Stage 1 Road Safety Audit

Castleconnell Flood Relief Scheme

On behalf of OPW / Limerick City & County Council

July 2024

Drawing Title  
**LAYOUT PLAN  
 SHEET 5**

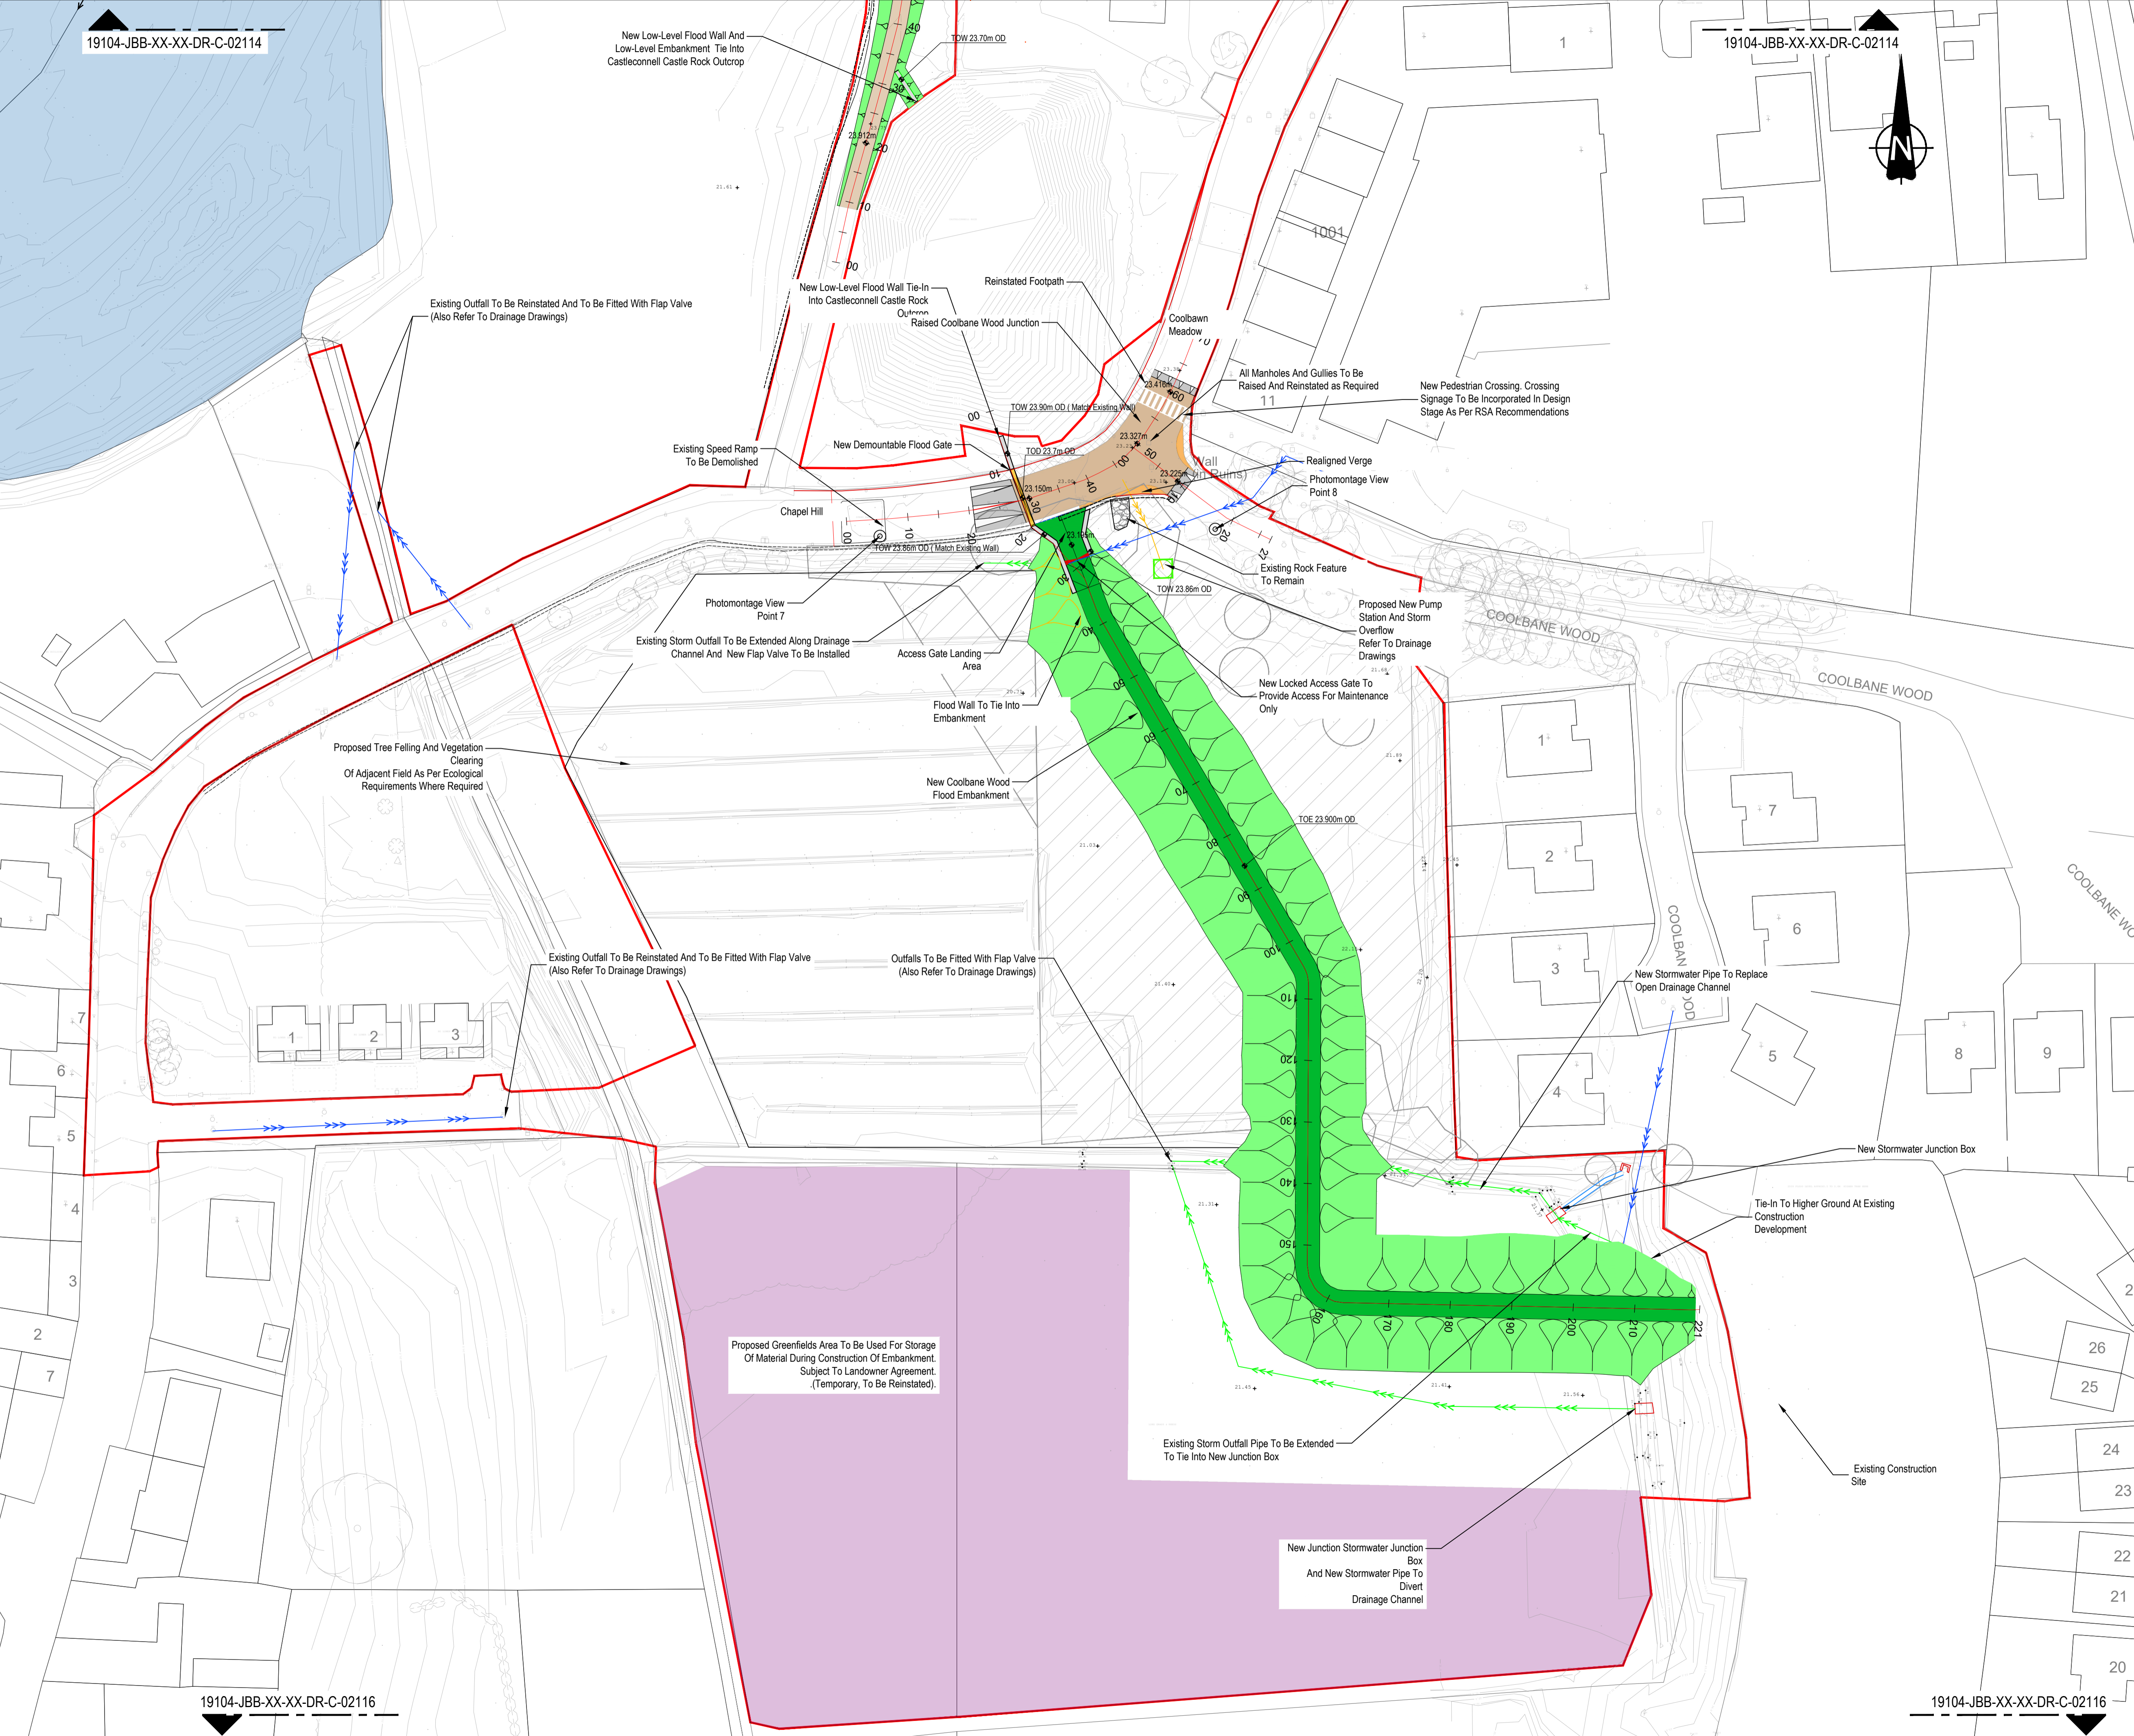
Problem: The revised road horizontal alignment appears to introduce sharp changes in direction to the western carriageway edge.

Problem: Visibility at the existing road junctions is already restricted by roadside boundary features. The proposed works result in a reduced carriageway width. This is likely to result in Mall Road traffic travelling closer to the eastern kerb and junctions off the road to the east than present.

Problem: The proposal is for 5.5m carriageway and 1.8m footpath. Whilst a 1.8m path may be adequate, 2.0m is normally now considered the default minimum footpath width. It appears that could easily be achieved.

Problem: The proposed flood defence wall is generally higher than the standard vehicle driver's eye height. The new wall proposed to the south of the Dunkineely driveway may restrict visibility for the exiting motorist.

Recommendation: The Design Team should redesign the alignment to provide a smooth western kerb line.

Recommendation: The Design Team should improve side road junction visibility as part of the works.

Recommendation: The Design Team should provide a minimum width footpath of 2.0m throughout.

Recommendation: The Design Team should ensure suitable driveway visibility is provided for users exiting Dunkineely House.

Drawing Title
**ELEVATIONS & LONGSECTIONS
SHEET 7**

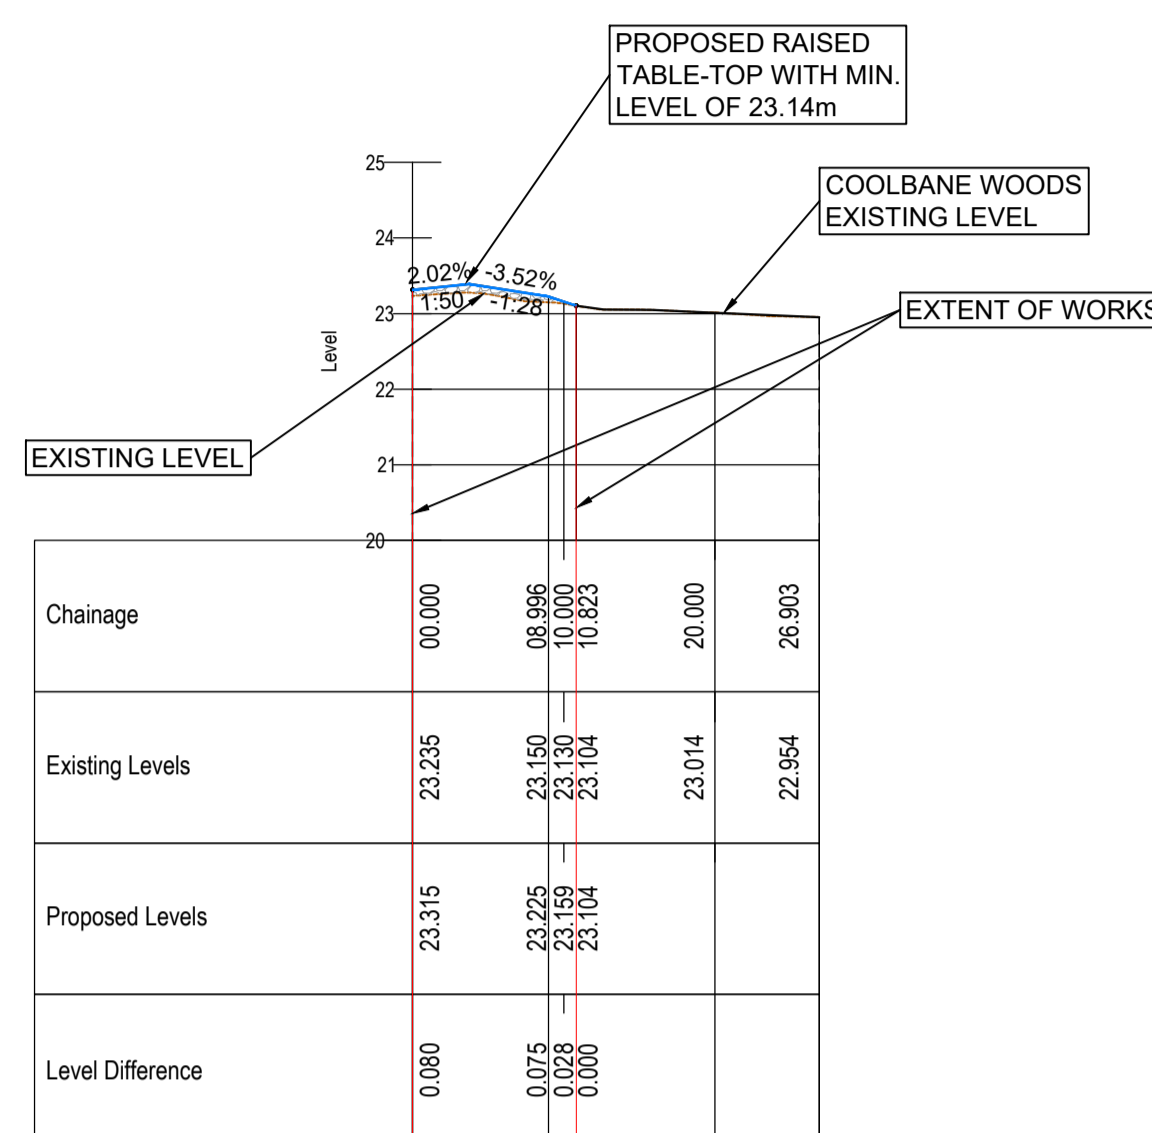
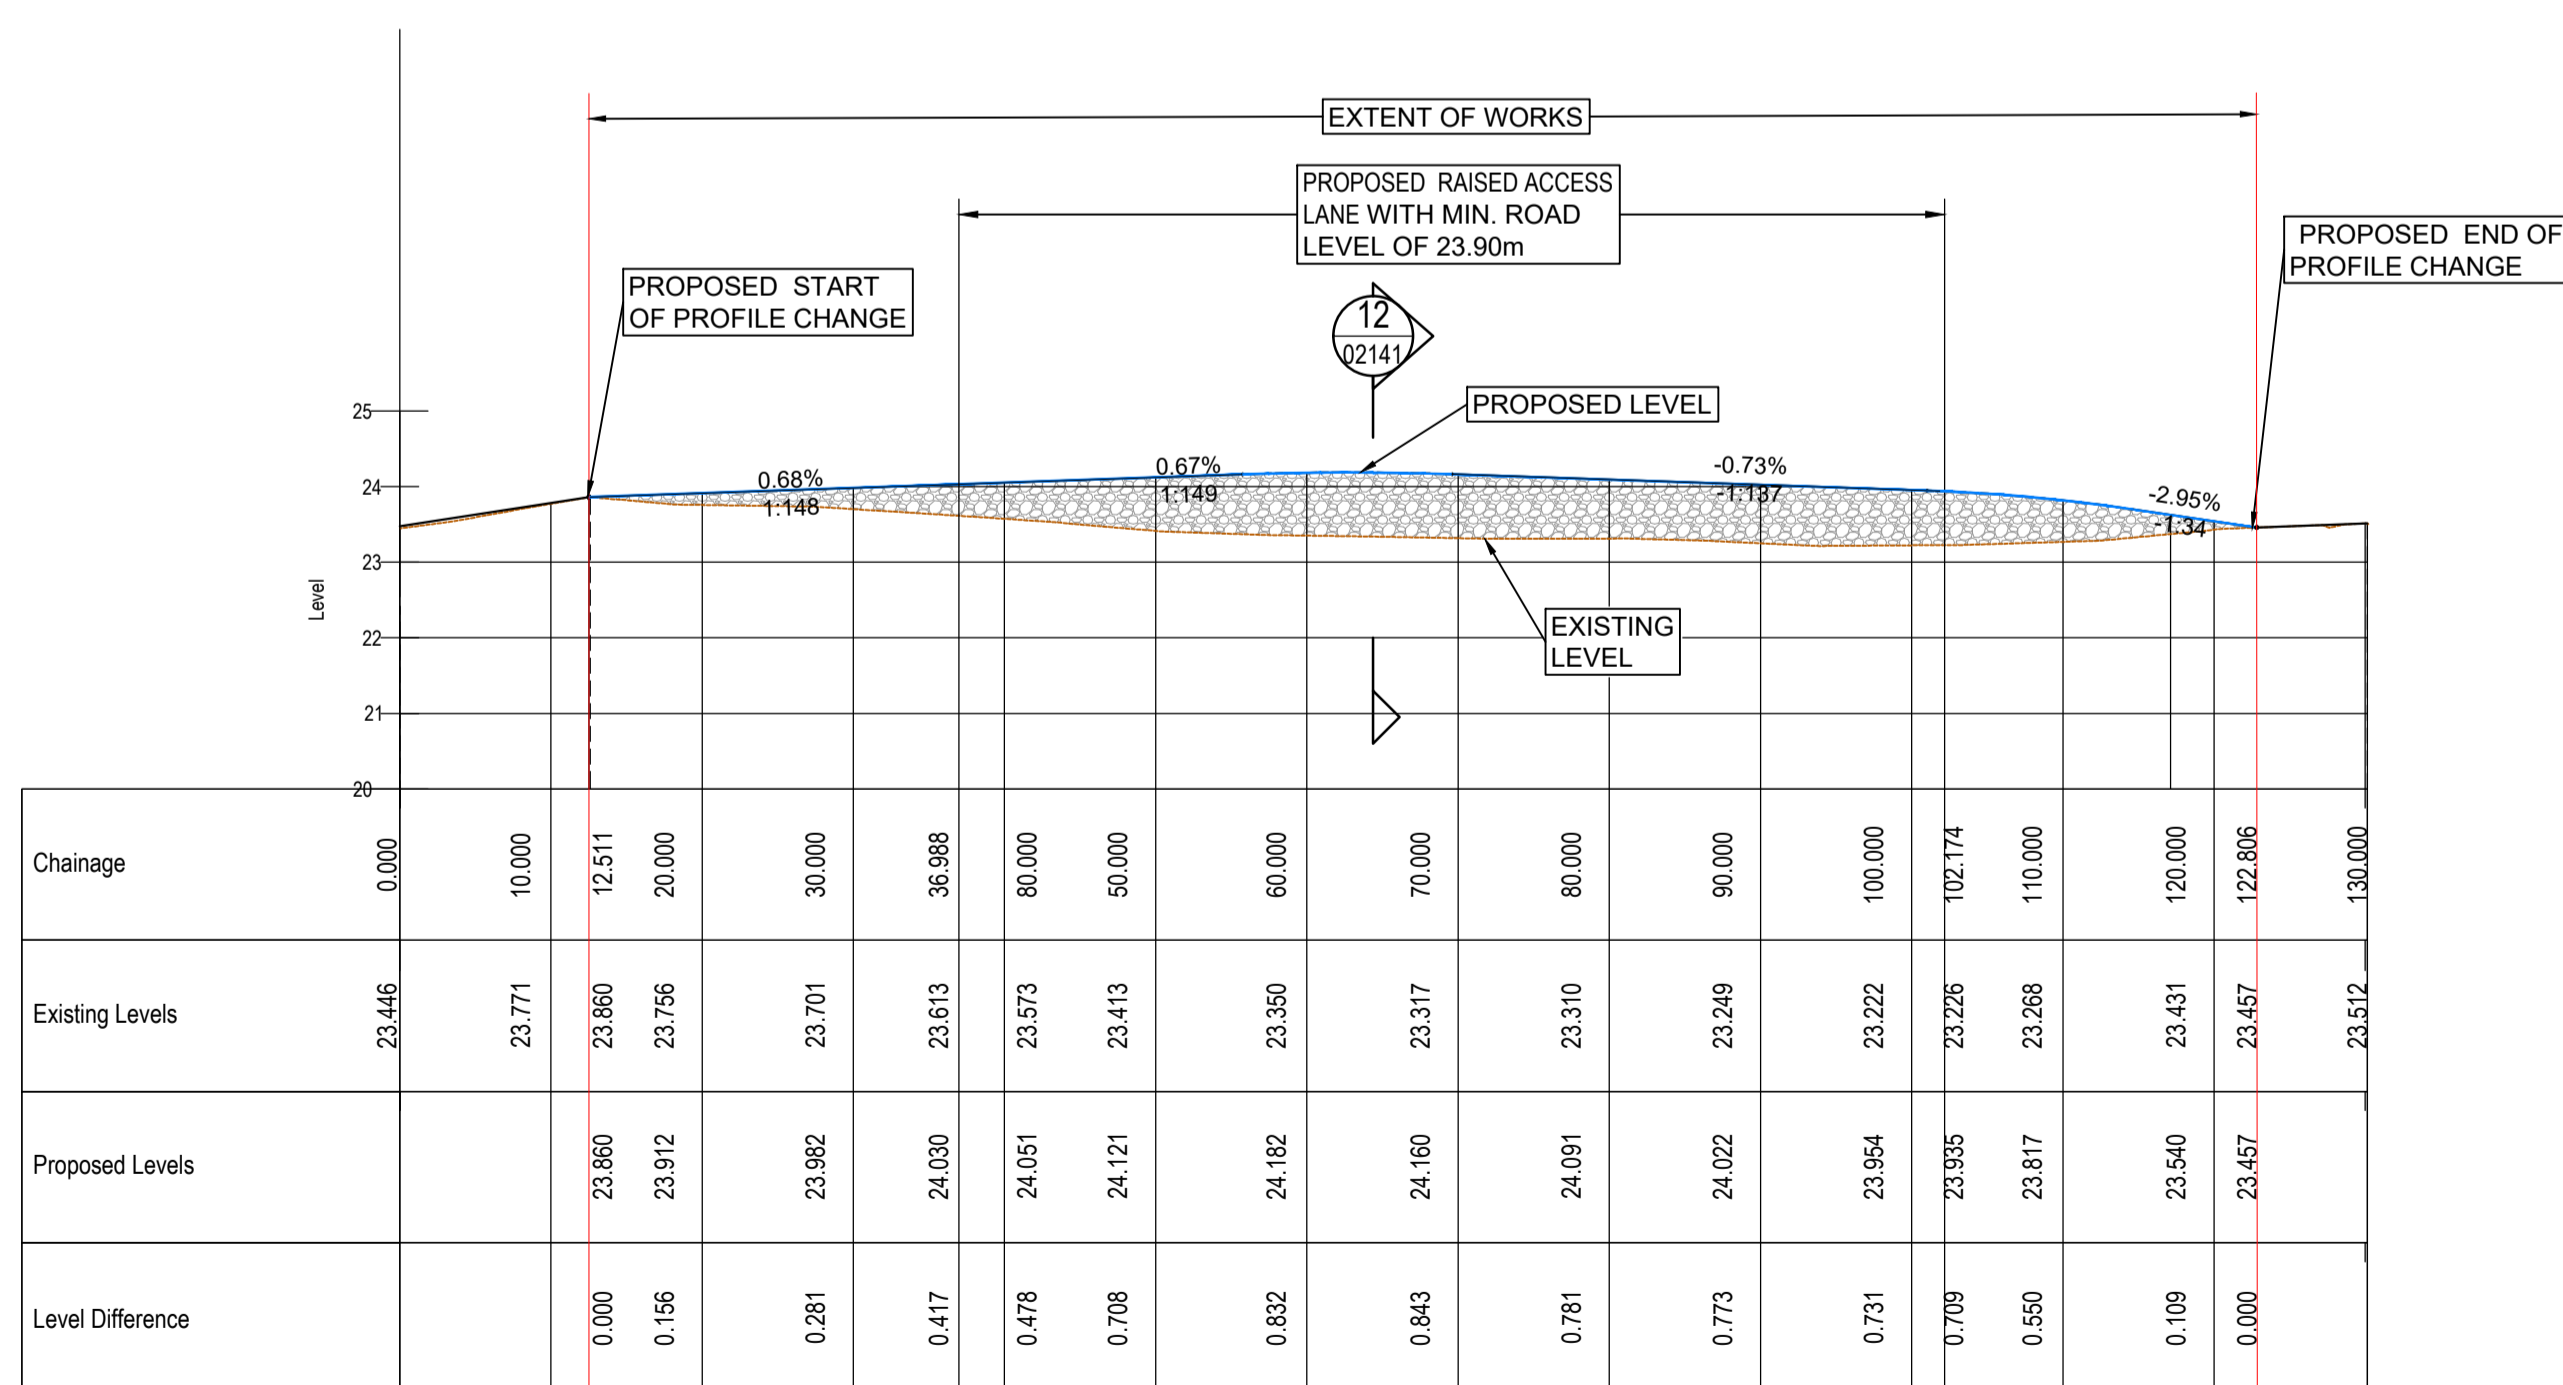
Problem: It is proposed to provide a demountable flood gate across Chapel Hill, south-west of the junction with Coolbane Wood. It is assumed that the gate will be erected when flooding is anticipated.

Hazard: Approaching drivers may not be aware of the flood gate placed across the road, especially given the restricted visibility for drivers approaching from Coolbawn Meadows. Vehicles may collide with the flood gate.

Recommendation: The Design Team should ensure that the flood gate is conspicuous, in terms of colour and reflectivity. Advanced signage/traffic management should be provided when the gate is closed. This could be achieved by using folding signs which are opened at the same time as the flood gate is erected.
